COMMUNITY DEVELOPMENT DEPARTMENT
501 Delta Avenue ♦ Marysville, WA 98270 ♦ (360) 363-8000

July 18, 2023

Re: Undi Commerce Park – *Technical Review 2*
PA 22008

CONCEPT GRADING PLAN

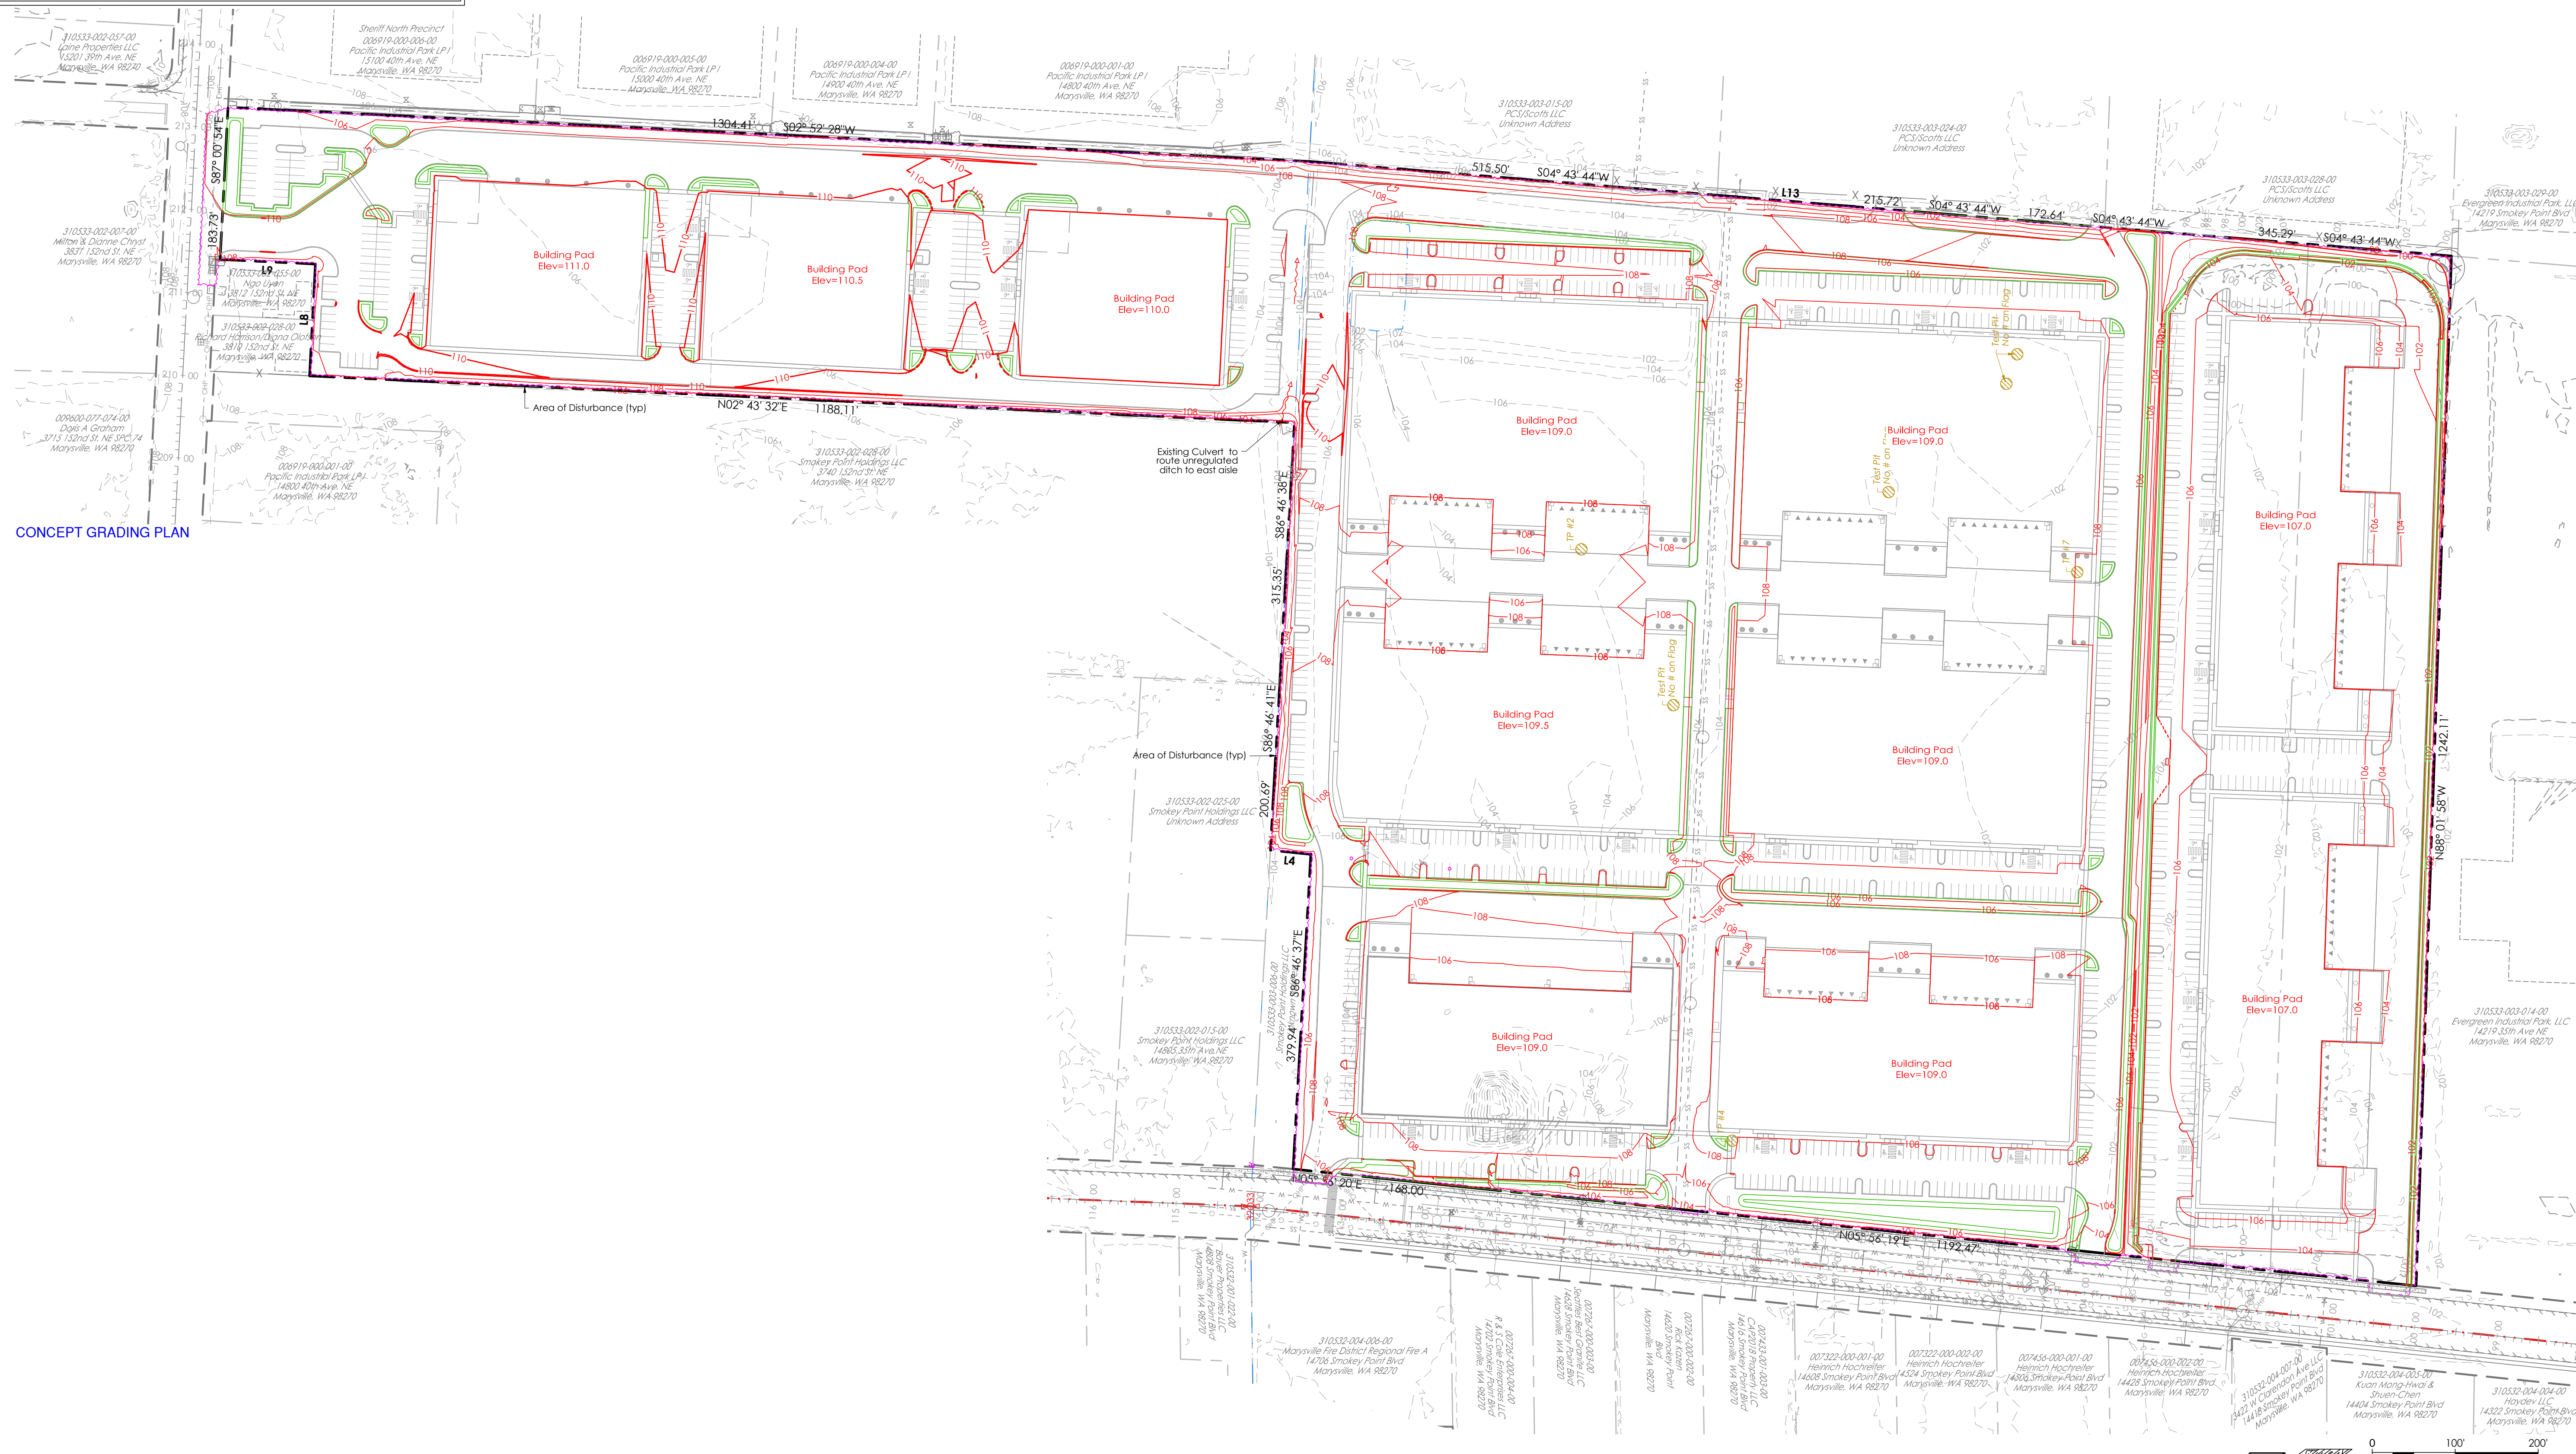
TR2 Comment: The site plan has changed significantly and it no longer appears that a portion of the site is proposed to be utilized by Scott's for fertilizer storage, however, the site plan is still showing an access to APN 31053300302400.

Has an easement been secured?

Has a NWP been obtained to fill the lineal ditch along the eastern portion of the site in order to access APN 31053300302400?

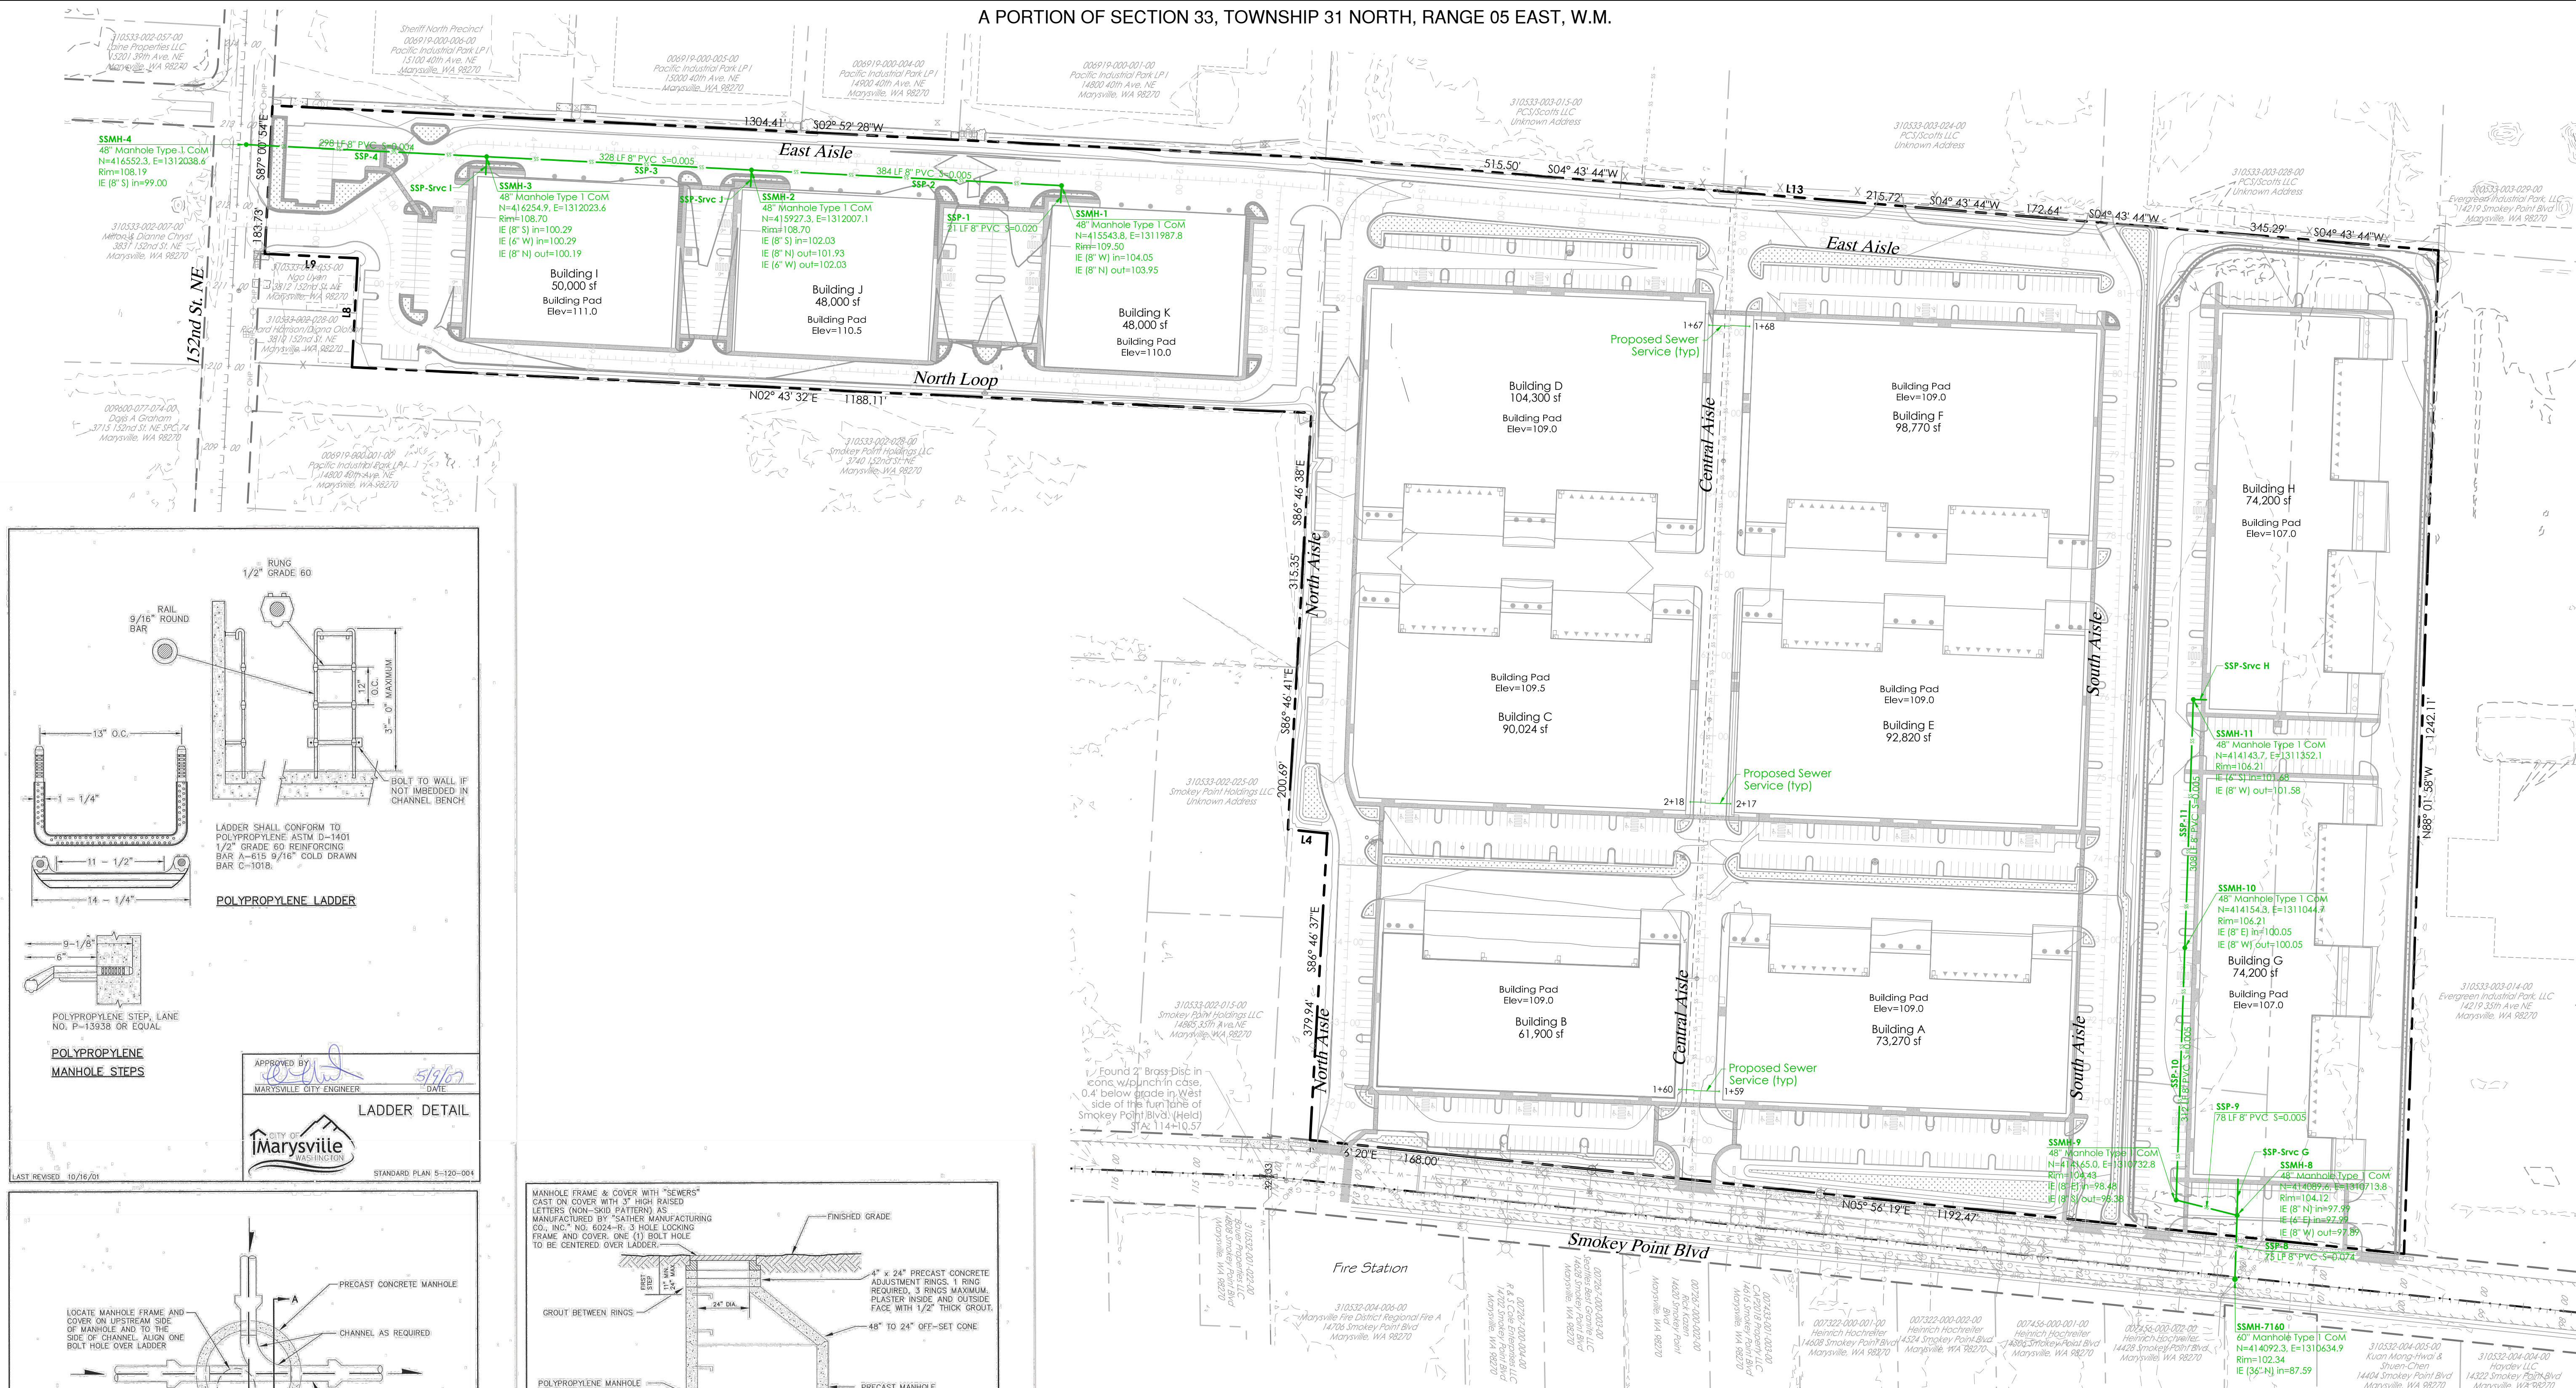
17. Water details not shown.
18. STA 0+00 east aisle tie in change to live tap.
19. Water main tee located between building K and D add 12" gate valve
20. N=414182.5, E=1311849.3 install 8" gate valve on line going to west
21. N=414733.5, E=1311168.1, what are the locations of the 3 gate valves on the cross
22. Locations for water services and meters both domestic and irrigation along with appropriate backflow prevention are not shown
23. Do not see locations of fire lines or FDC. All fire lines will require a valve at water main connection.

sheet
A1.2

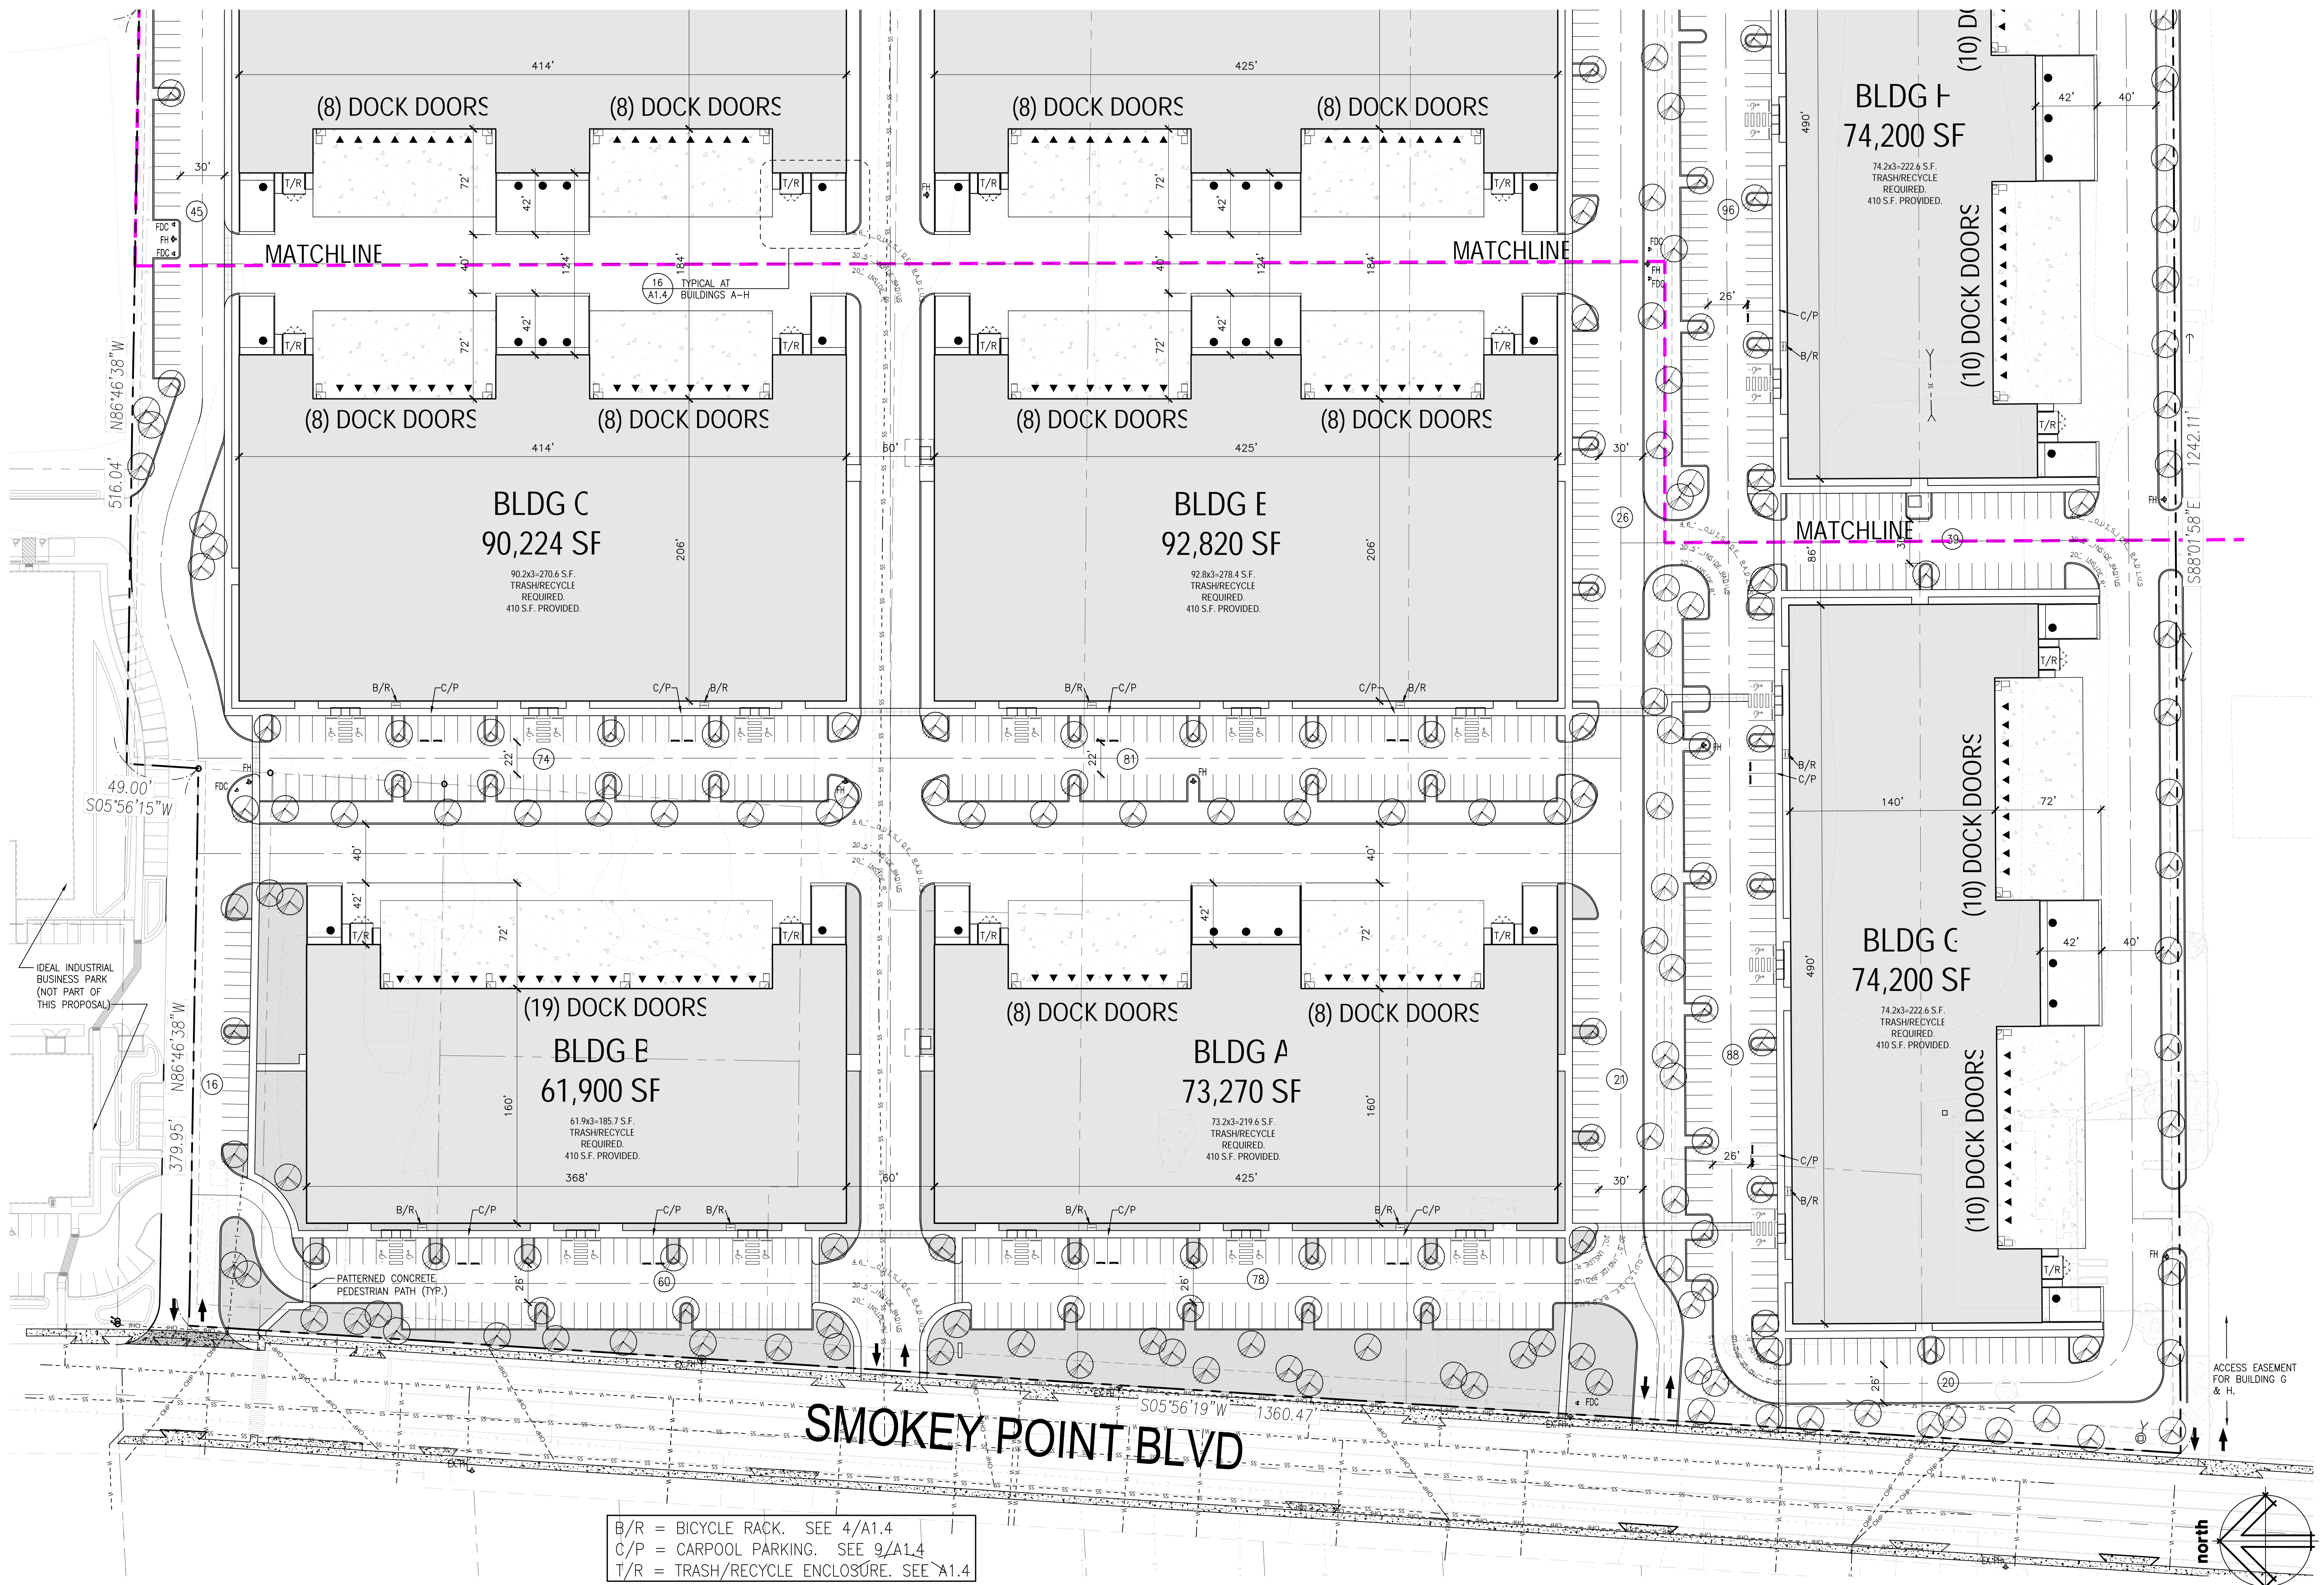
1. The ARCH Site Plan shall be amended, as follows:
 - a. Provide a cover sheet that includes the entire development site, similar to Sheet C1.
 - b. A pedestrian connection will need to be provided from the sidewalk on 152nd Street NE and Building I.
2. **TR1 Comment:** The amended NWP issued by the US Army Corps of Engineers (Corps) authorizes 1,300 c.y. of fill to install a two 36-inch and one 18-inch diameter culvert in an unnamed ditch. The approval was valid through March 18, 2022, unless the NWP is modified, reissued, or revoked prior to that date. However, if, the authorized work has not been completed by that date and you have commenced or are under contract to commence this activity before March 18, 2022, you will have until March 18, 2023, to complete the activity.
